March 6, 2023

Re: BCOM2302-0007

The plans for The Springs of Ballentine have been reviewed but cannot be approved at this time. Additional information is requested in order to complete the review. Please provide and/or clarify the following:

**1 LAUNDRY/CARE BASE/MEDS/SERVERY/STAFF LOUNGE & BEAUTY**  
1/4" = 1'-0"

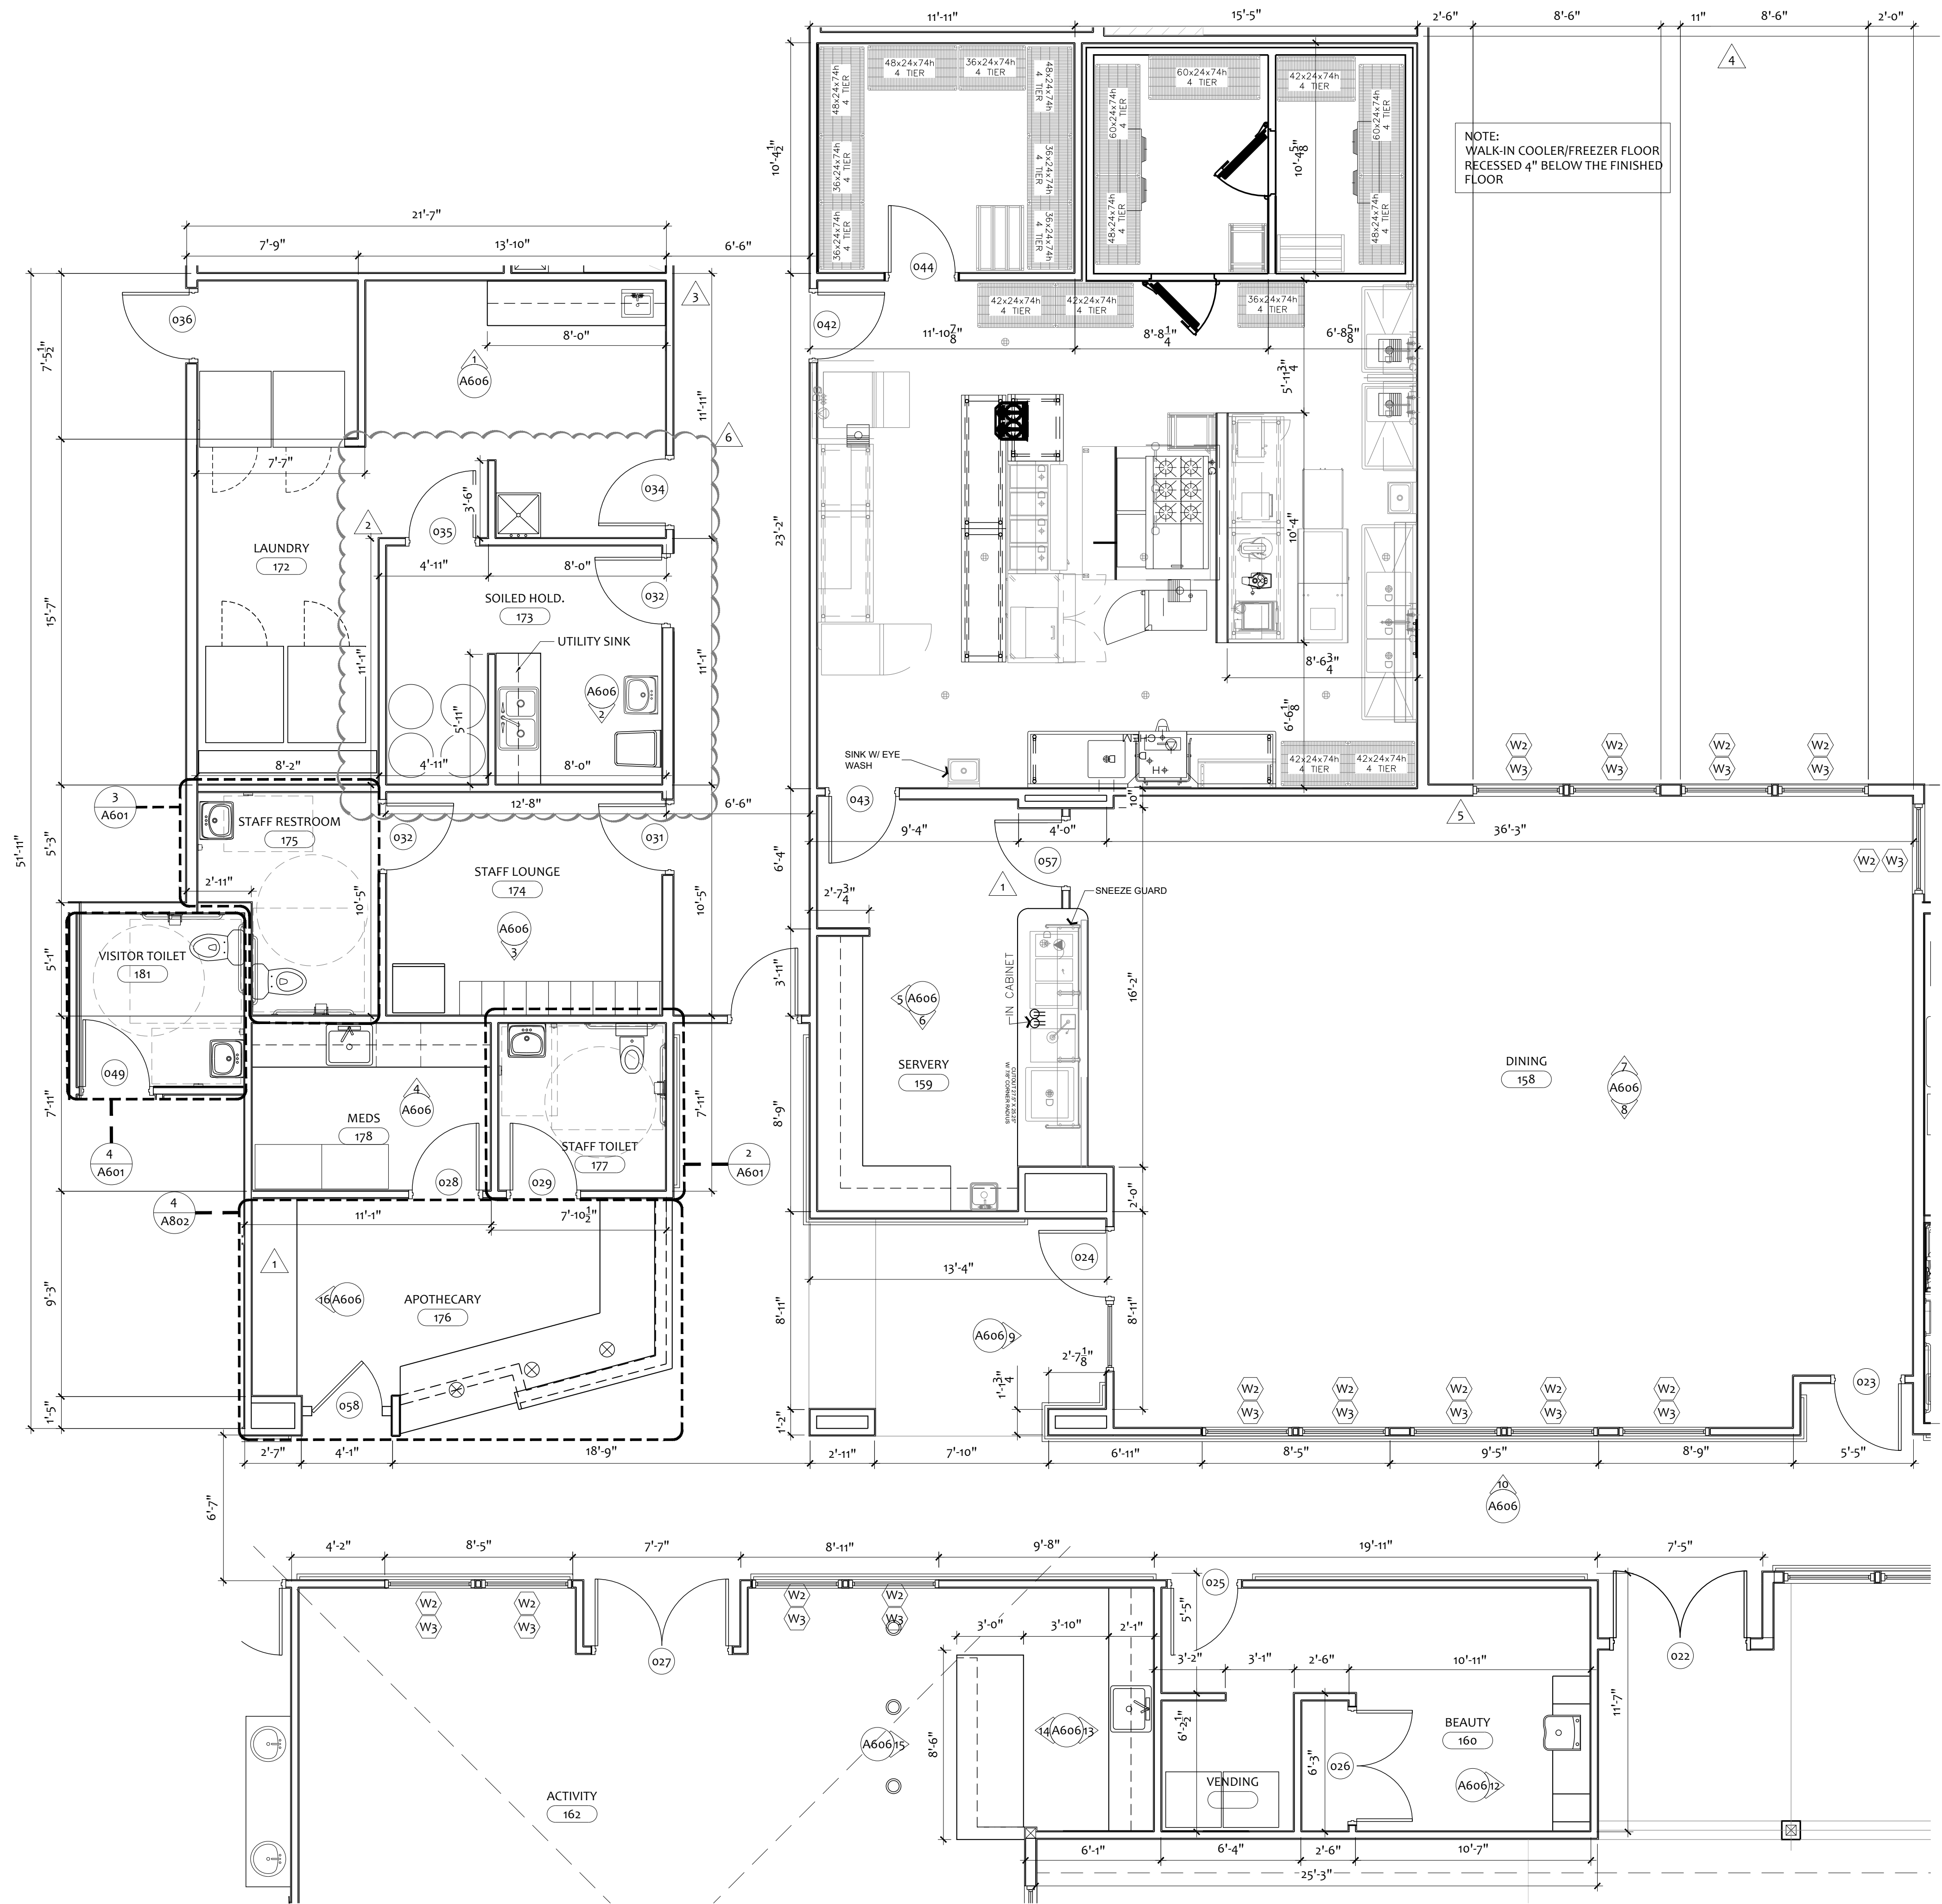
1. Provide a site plan of the laundry areas and label the equipment on the site plan. Provide a corresponding equipment specification sheet for the equipment in these areas.

5. Indicate the intended use of the sink in the clean linen area of the laundry room.
6. Will the facility have shower beds, shower chairs, raised toilet seat with frame, and other assisting type equipment? If yes, than provide the location these items will be cleaned and disinfected.
